## Chief Executive's Report

Response to An Bord Pleanála in accordance with the requirements of Section 8(5)(a) of the *Planning and Development (Housing) and Residential Tenancies Act 2016*

ABP Case Number: TA29N.314019

**Development Location:** At the Junction of Santry Avenue & Swords Road, Santry, Dublin occupying the site of the existing Chadwick Builders Merchants

North Elevation
SCALE : 1:200

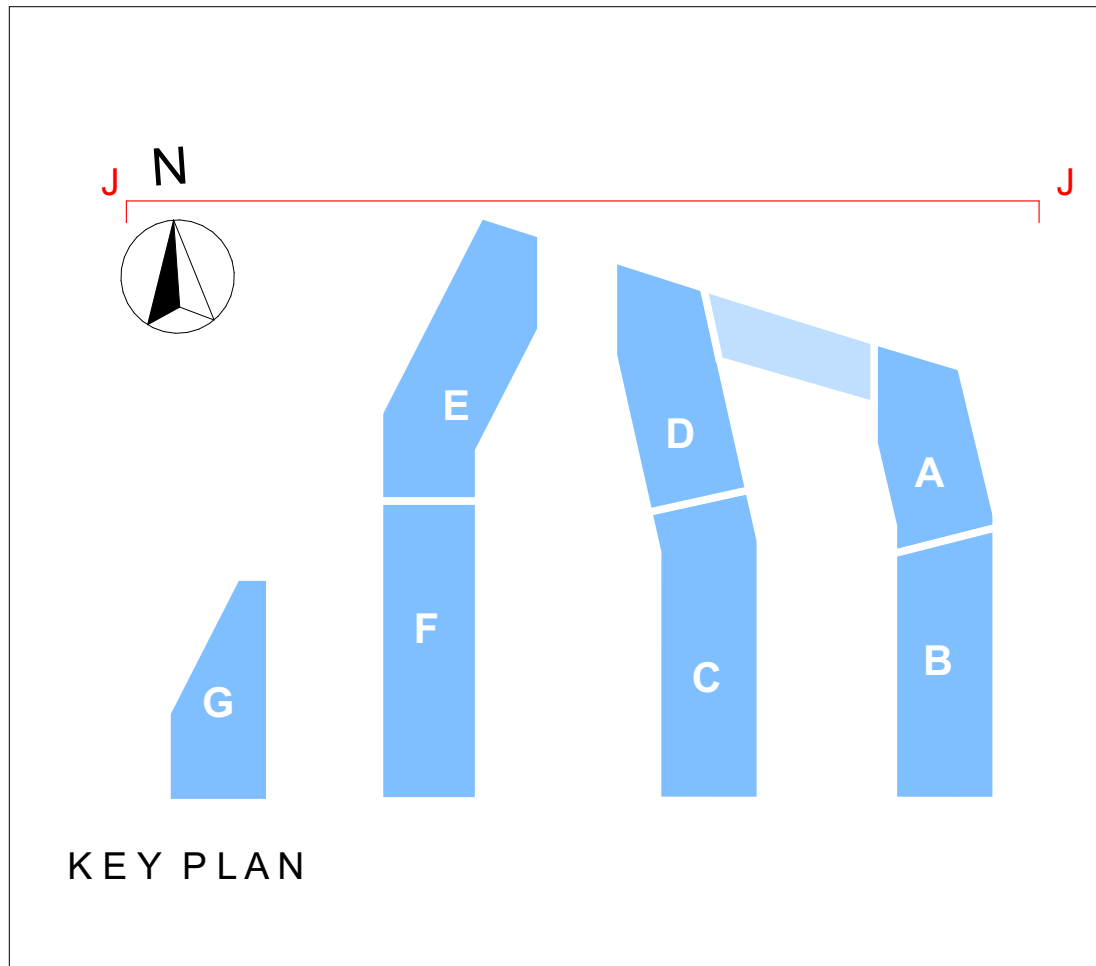
The applicant has proposed the highest building at the corner of the site where the Swords Road meets Santry Avenue and decreases to 7 storeys southwards along Swords Road and increases to 2no. 10-storey blocks along Santry Avenue. Notwithstanding its relatively unrestrained corner location, as previously noted, the planning authority considers the 14-storey (48 metres) height of Block A at this location to be particularly excessive, failing to integrate successfully into its immediate environs.

The height of the taller blocks, D & E) to the south of this roadway and pathways would serve to dominate and have an overbearing impact on the public domain and significantly increase overshadowing and have an overbearing impact on the immediate environs. The transition between the established and permitted developments in the area and this proposed development is considered abrupt and does not respond appropriately to the surrounding built environment and has insufficient regard to its context.

As with block A, there are no setbacks on the upper levels of Blocks D and E to soften the impacts.

It is considered that a reduced height for Blocks A, D and E would address the concerns of the planning authority – see below for recommendations with regard to reduced height.
